20th April 2020

Town & Country Planning Act 1990 (as amended)
Town & Country Planning (Development Management Procedure) (England) Order 2015
Application for Planning Permission for Works or Extension to a Dwelling

Development Loft conversion with hip to gable extension and dormer, single storey rear and side extension and render and cladding to extension facade
Location Southgate Lincoln Avenue Aldwick

SITE PLAN
PROPOSED
1:250 @ A1

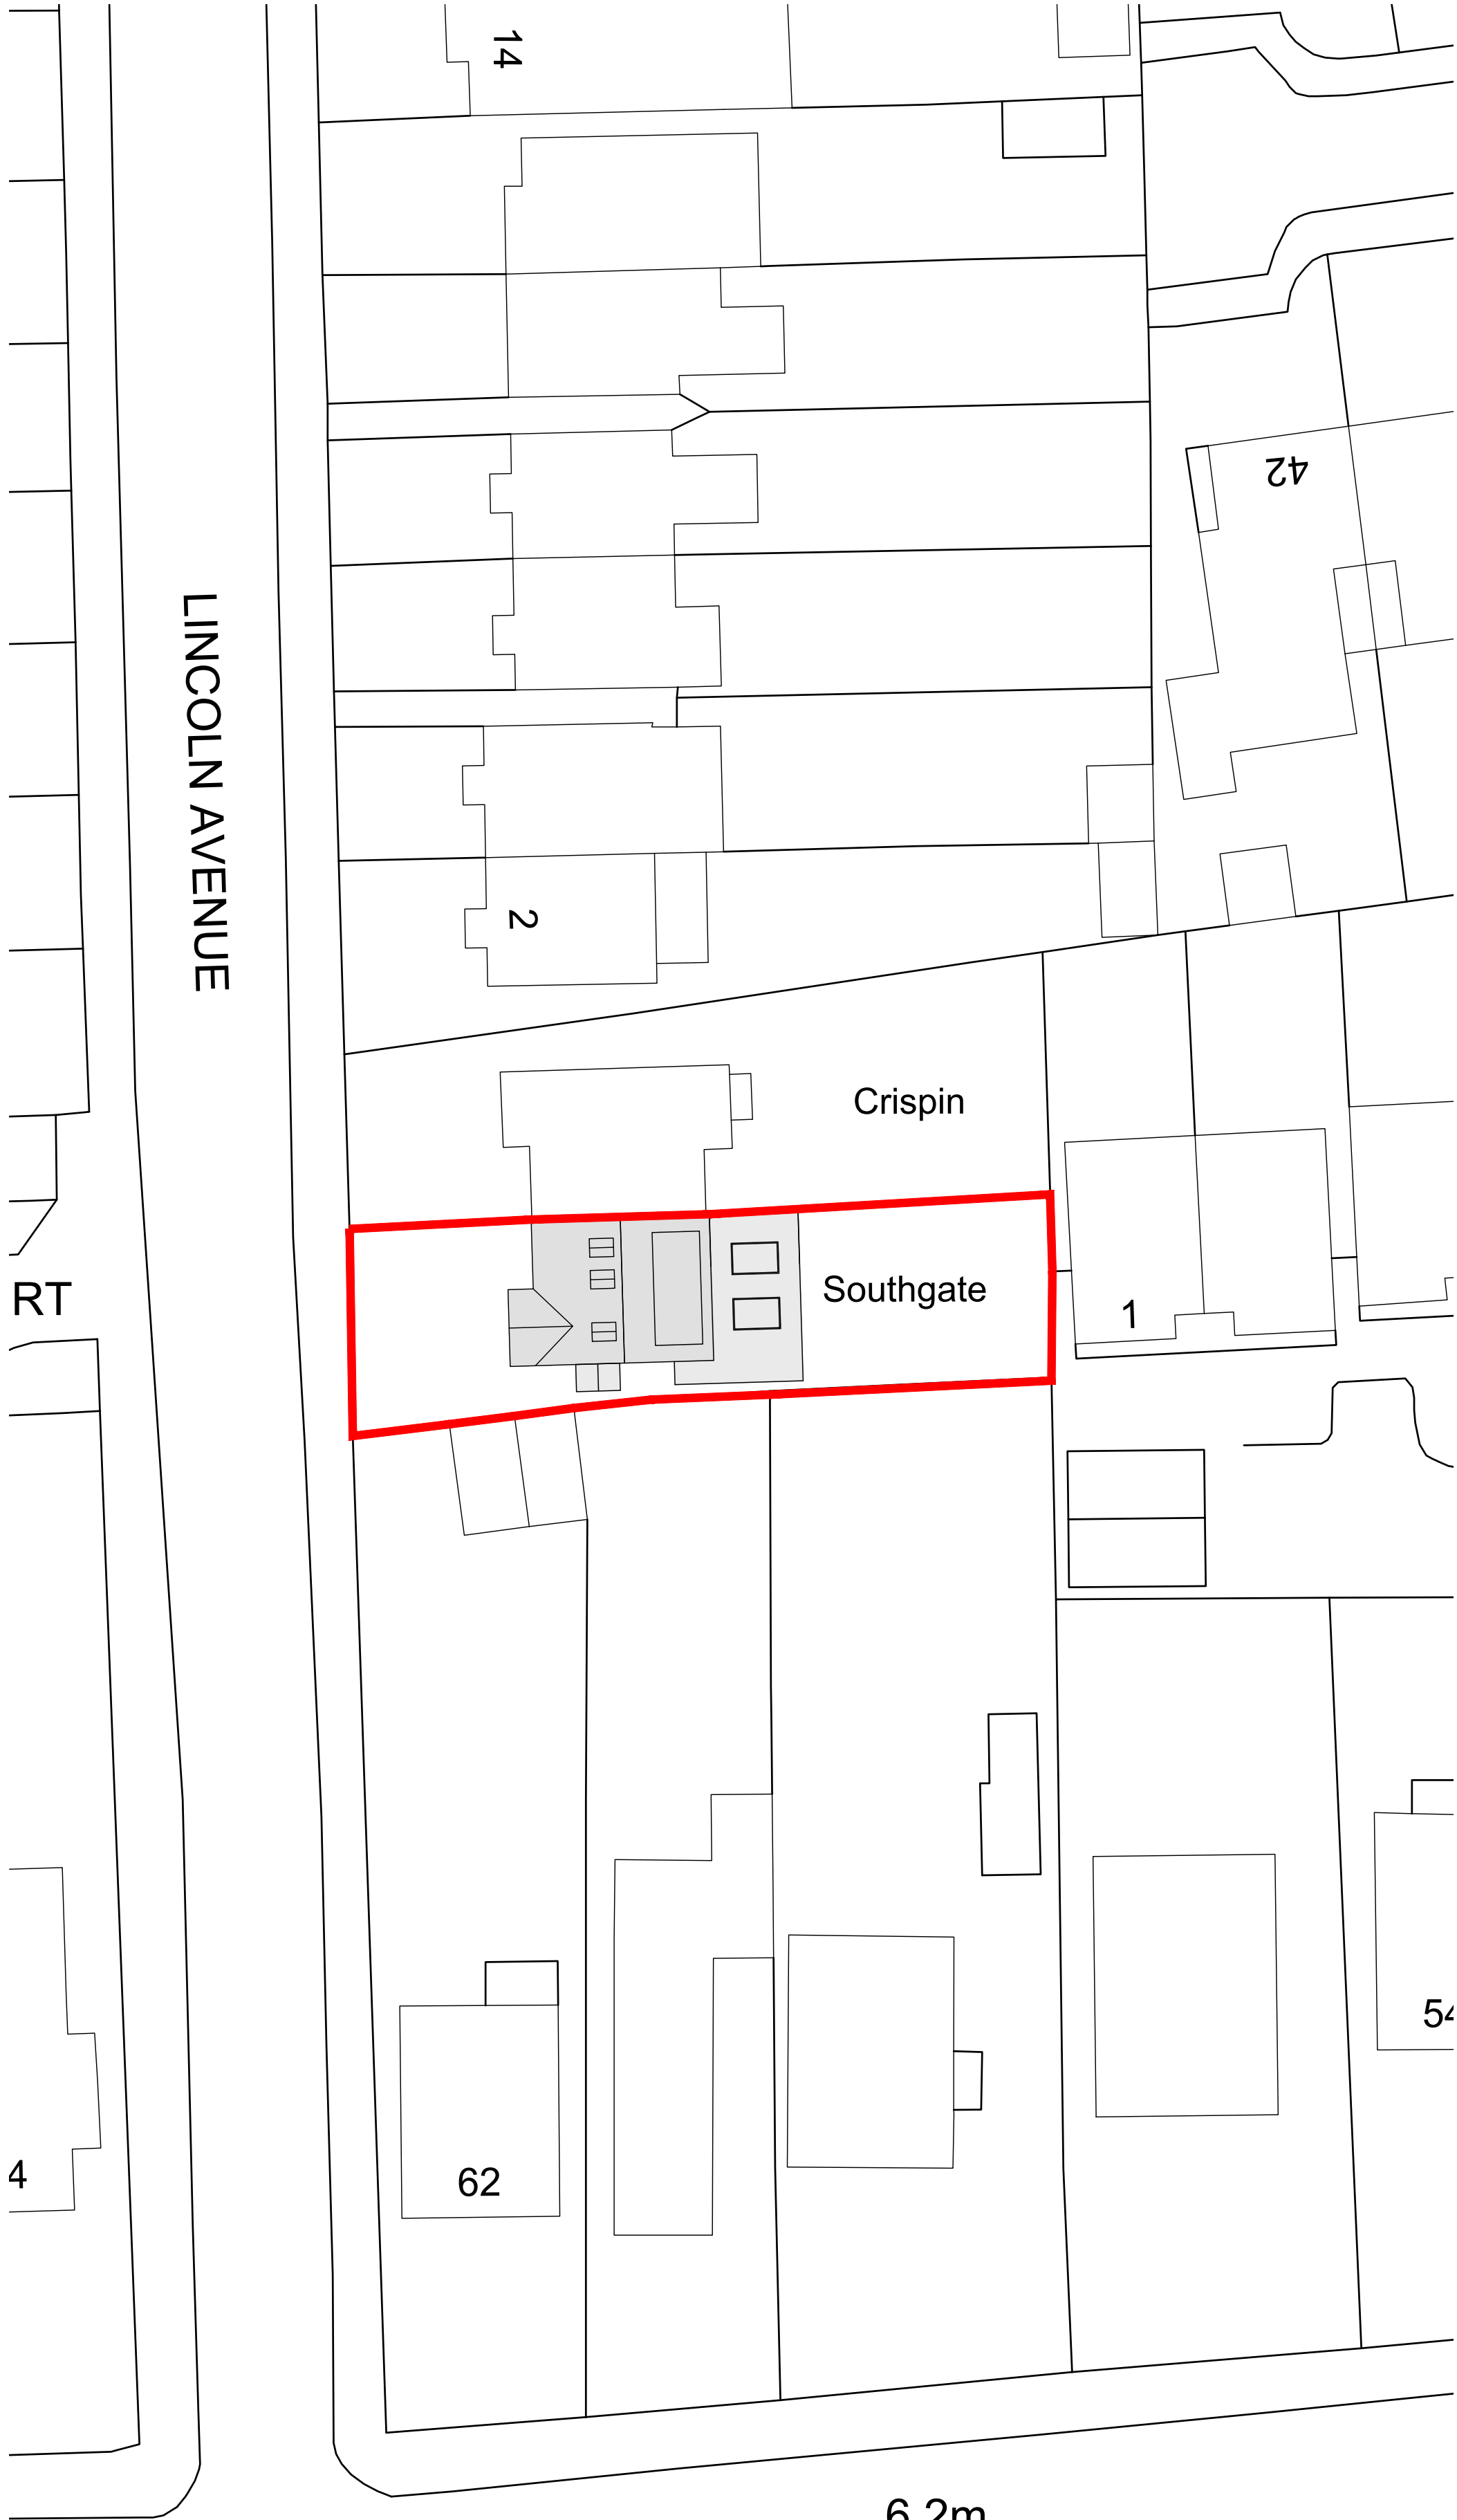
Block Plan: You are required to include dimensions from the proposed extension to all site boundaries.
